SSD-8392 APPLICATION – PROPOSED DARLINGTON POINT SOLAR FARM, DONALD ROSS DRIVE DARLINGTON POINT.

Roads and Maritime Services has reviewed the Environmental Impact Statement (EIS) and Traffic Impact Assessment prepared by ARUP for the Darlington Point Solar project. From the information provided it is understood that the proposal is for the establishment and operation of a 275 MW solar photovoltaic (PV) plant and associated infrastructure on the subject site. The subject site has frontage and access to Donald Ross Drive, which is classed as a local road, within a 100 km/h speed zone.

Sturt Highway and Donald Ross Drive
AM Peak
2018 Post
Giveaway / Yield (Two-Way)

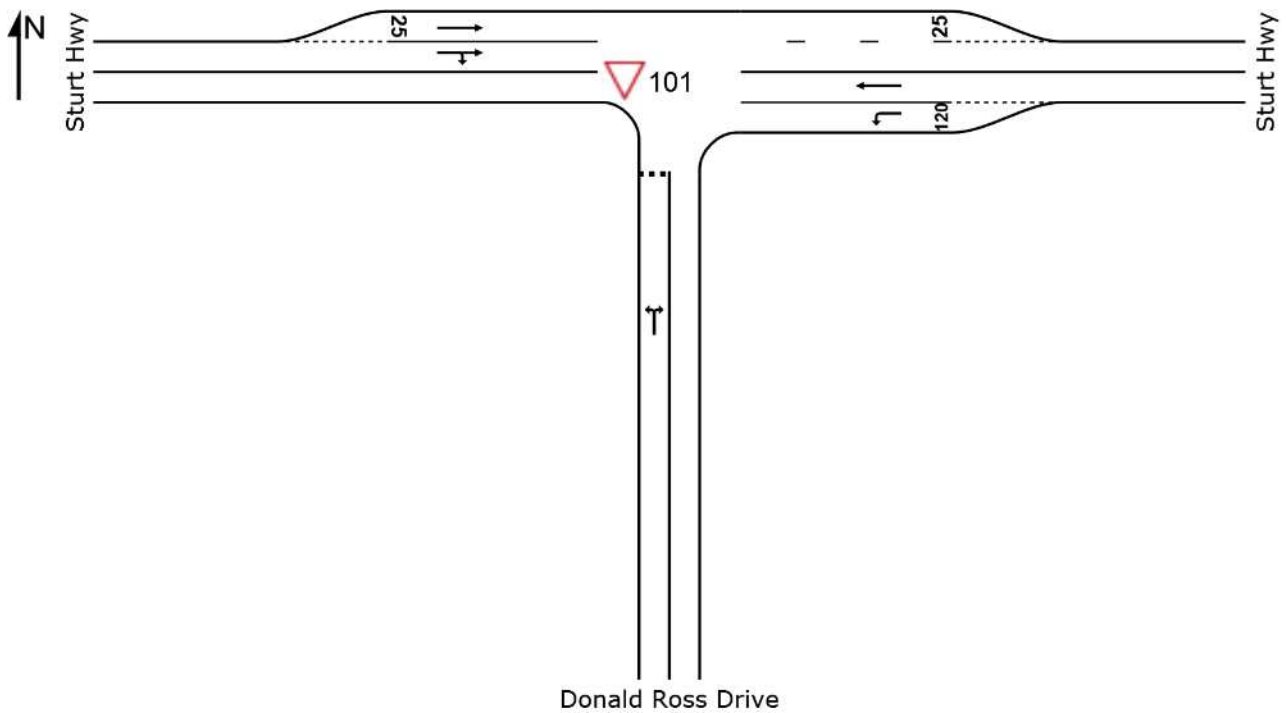
The submitted documentation indicates that access to the development site is proposed from Donald Ross Drive and through its intersection with the Sturt Highway. The intersection of Donald Ross Drive with the Sturt Highway is currently constructed with a sealed Auxiliary Right Turn (AUR) and Auxiliary Left Turn (AUL) treatment from the Sturt Highway. The intersection of the Kidman way with Ringwood Road is a sealed 4 way intersection with limited turn treatment.

The submitted documentation fails to provide sufficient detail to identify the types, volumes and origin/destination of delivery, construction and personnel traffic generated during the construction period. The current intersection of Donald Ross Drive with the Sturt Highway is currently constructed to an appropriate standard to accommodate the anticipated traffic generation. Based on the information provided access to the development site, particularly for heavy vehicles, should be restricted to via the intersection of the Sturt Highway and Donald Ross Drive. As Donald Ross Drive is classed as a local road access to the site from this road shall be to the satisfaction of Council.

2. Vehicular access to the development site, particularly heavy vehicles, shall be restricted to via the intersection of the Sturt Highway and Donald Ross Drive.

New Site
Giveaway / Yield (Two-Way)

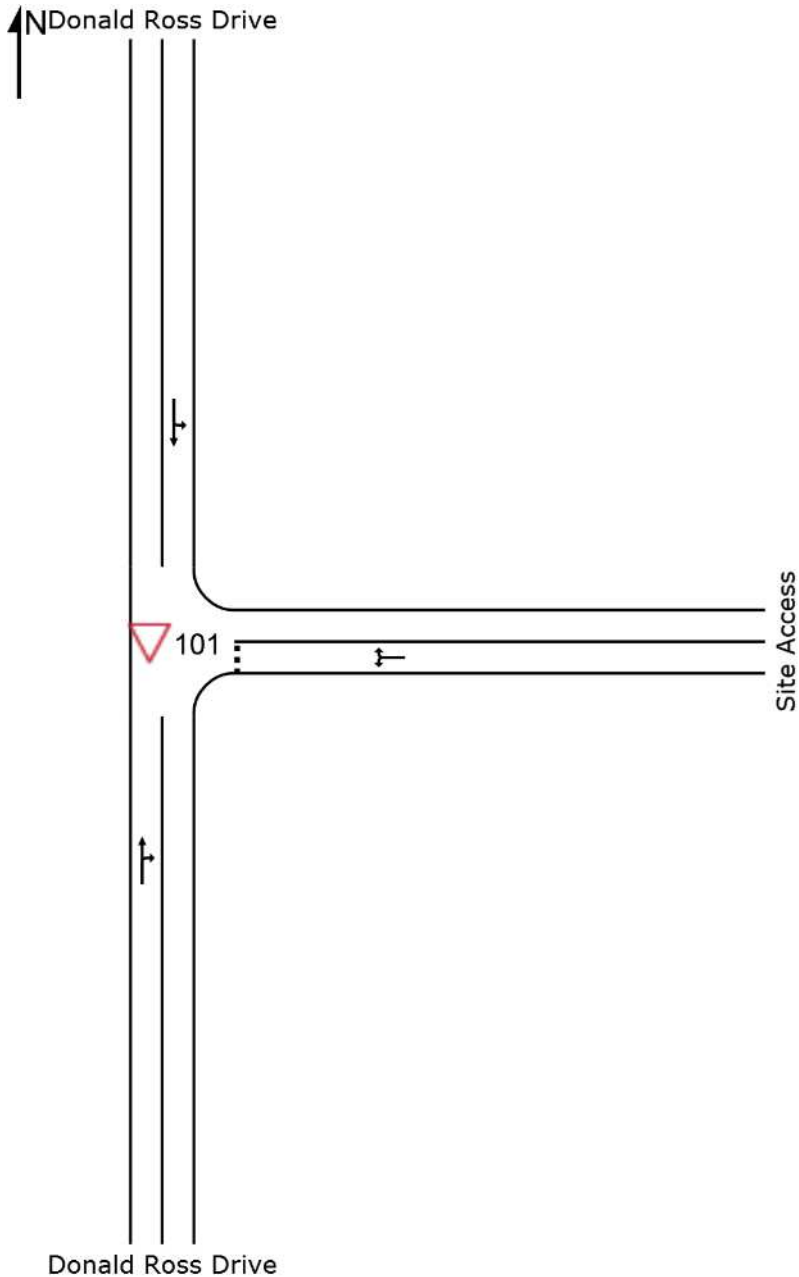
The site does not have frontage to the Sturt Highway or Kidman Way but will rely on access by these roads for workers and delivery of components. Access to the development site is proposed from Donald Ross Drive. It is understood from the submitted documentation that access to the site will be via the intersection of Donald Ross Drive with the Sturt Highway or Ringwood Road with the Kidman Way during both the construction and operational phases of the project. As access to the development site is proposed from Donald Ross Drive any access driveway should be consistent with the requirements of Council.
